Cockle Bay Park – Response to Agency Submissions

7.7 Temperature – after 5 minutes

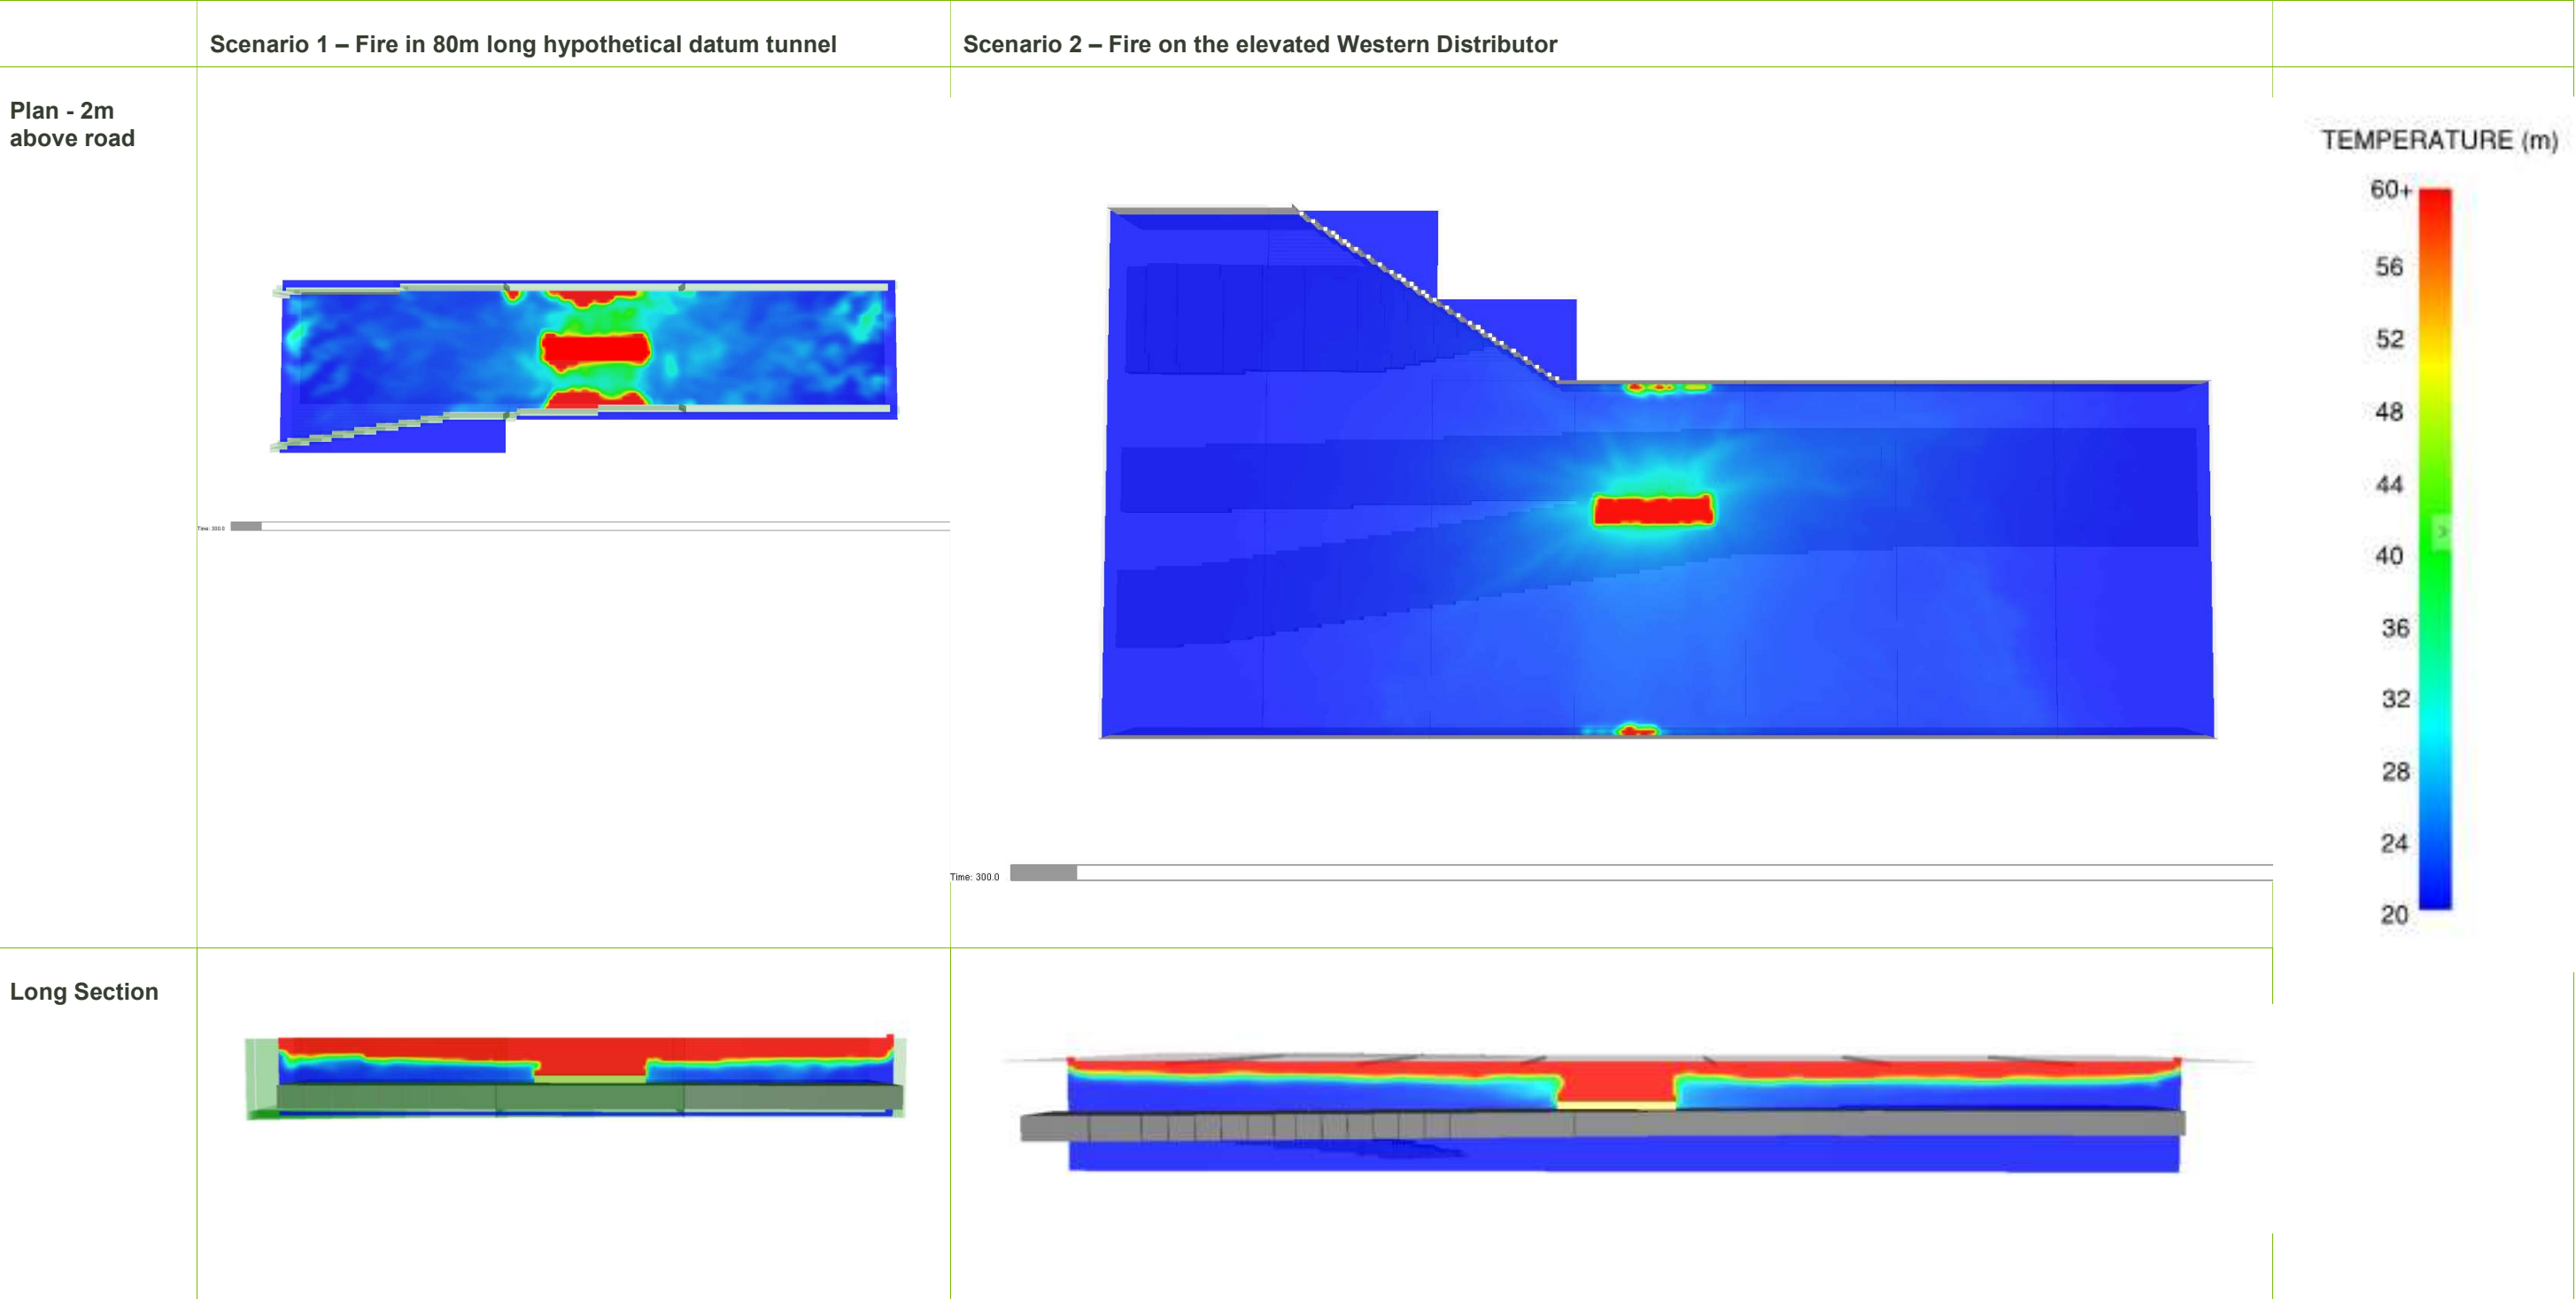
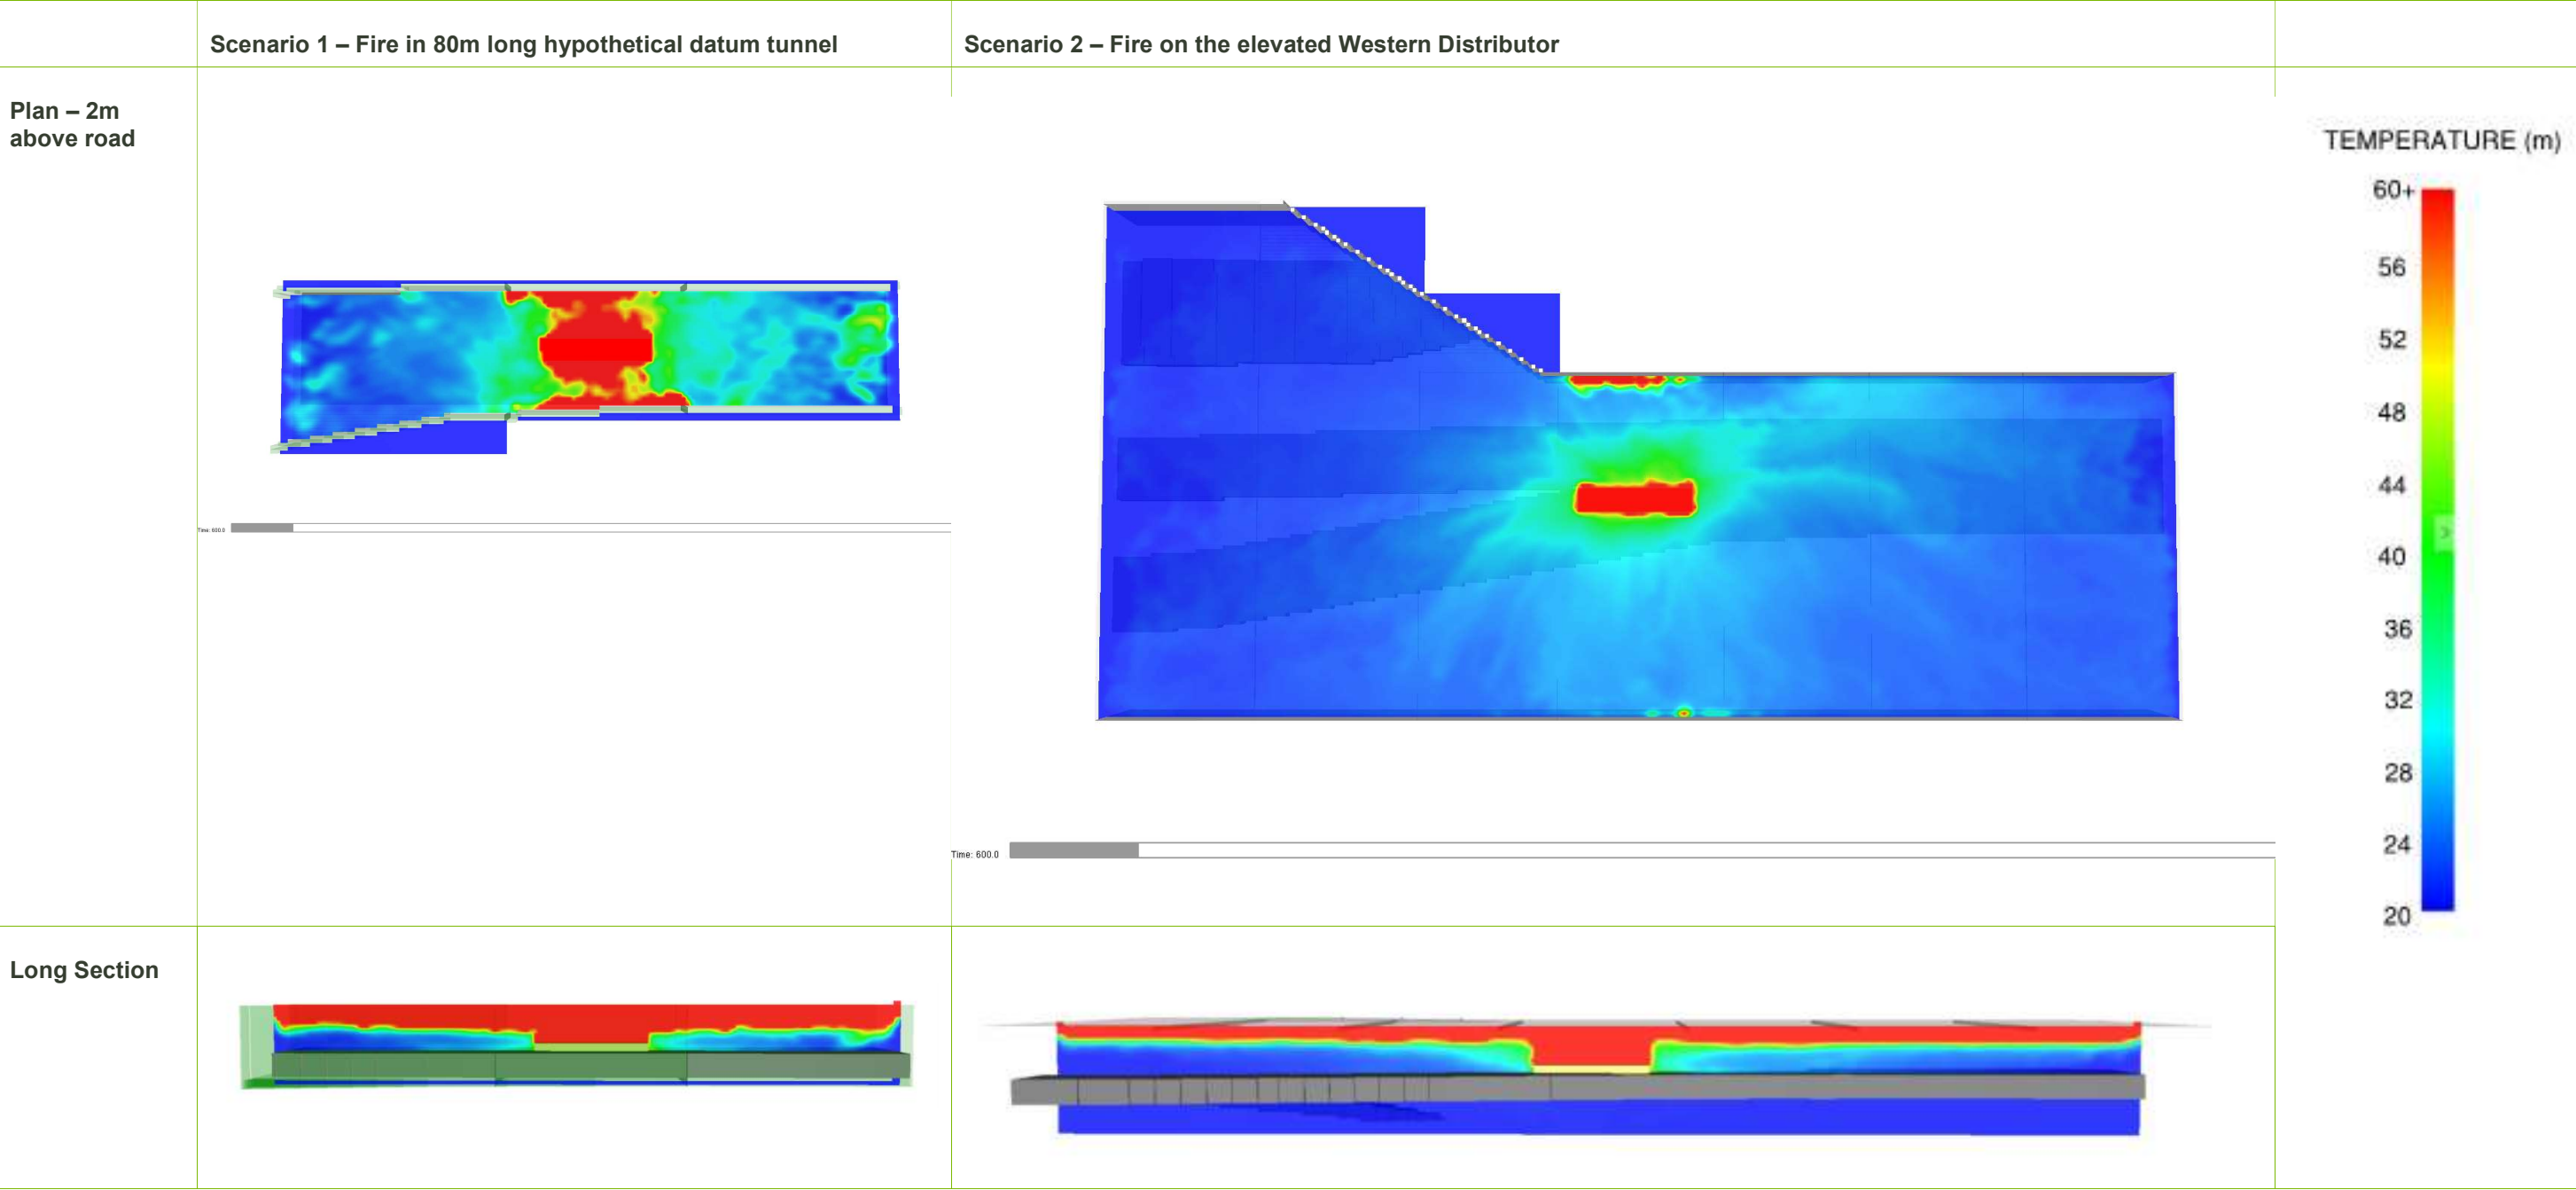
<p>Fire safety – the proposal has the effect of creating a tunnel underneath the podium – adequate provision of fire safety must be provided regarding traffic flow</p>	<p>Fire safety design criteria regarding the Western Distributor as it travels under the landbridge have been developed by Aurecon, in consultation with RMS (refer to Appendix J1). The design criteria are to be implemented at the relevant future stages of detailed design to ensure adequate fire safety provision is achieved.</p>
<p>Piering Options – RMS has request no piers in addition to the proposed piers option</p>	<p>Enstruct and Aurecon have considered structural options for landbridge pier locations including piers between on-grade northbound Harbour St and the elevated Western Distributor and an alternate 'no piers' option. The options are presented at Appendix K and Appendix W (refer to Section 7.20 of the</p>
